Recommendation Report for Planning Permission for Works or Extension to a Dwelling

REF NO: BN/108/25/HH

LOCATION: Anchor Bay
2 Downview Road
Barnham
PO22 0EE

PROPOSAL: Erection of car port.

Customer Signature
To Confirm & Return:
Signed: _____
Date: ____ / ____ / ____
(refer to above plan for exact dims) #
1 x 9.1m x 5.4m Chart C/House
Incorporating:
3 x 3.0m x 5.4m Open Bays
CHART CARRIAGE HOUSE Range
Shiplap Cladding

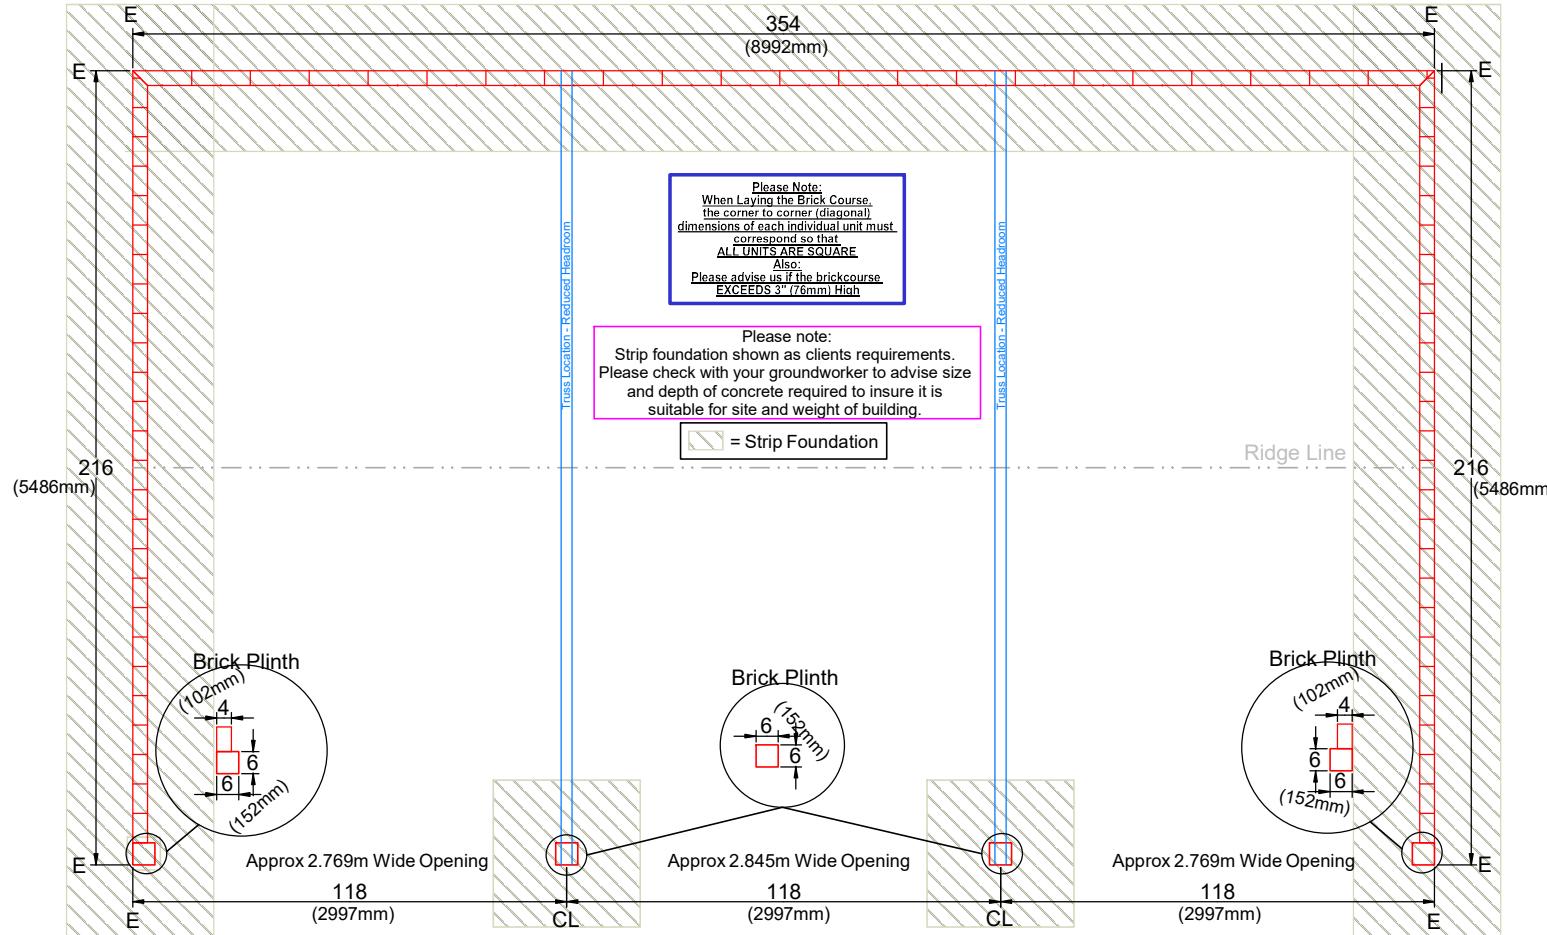
Insufficient information regarding surface water drainage has been submitted to evidence that flood risk will not be increased as due to the proposed development.

No formal drainage strategy has been provided. The Lidsey Drainage Statement indicates that runoff

from the carport will be drained to ground. If infiltration is later found not to be viable, then water would be attenuated and discharged at a restricted rate to an unspecified 'legal' outfall. Due to the lack of supporting detail, we are unable to ascertain whether the proposed development would accord with Standard 1 of the NSfS. Consequently, we object to the proposal, as it has not been demonstrated that the surface water drainage for the carport will avoid increasing flood risk on site or elsewhere.

At present, no modelling or supporting evidence; such as ground investigations or drainage plans have been submitted for engineering assessment. In the absence this evidence, we cannot assess if flood risk will be increased by the surface water drainage of the proposed development. Therefore, this application does not accord with the NPPF as set out above.

Insufficient information regarding the construction, operation and maintenance of the SuDS system, and therefore Standard 8 of the Systems NSfS. There appears to be one significant existing tree which could impact the scale and layout and location of SuDS features, as such it is not appropriate to secure details via condition. Accordingly, we object to the proposal on this ground, and require the applicant to provide

details of existing trees and plans that demonstrate that any SuDS features do not conflict with them to ensure compliance with Standard 8 of the NSfS.
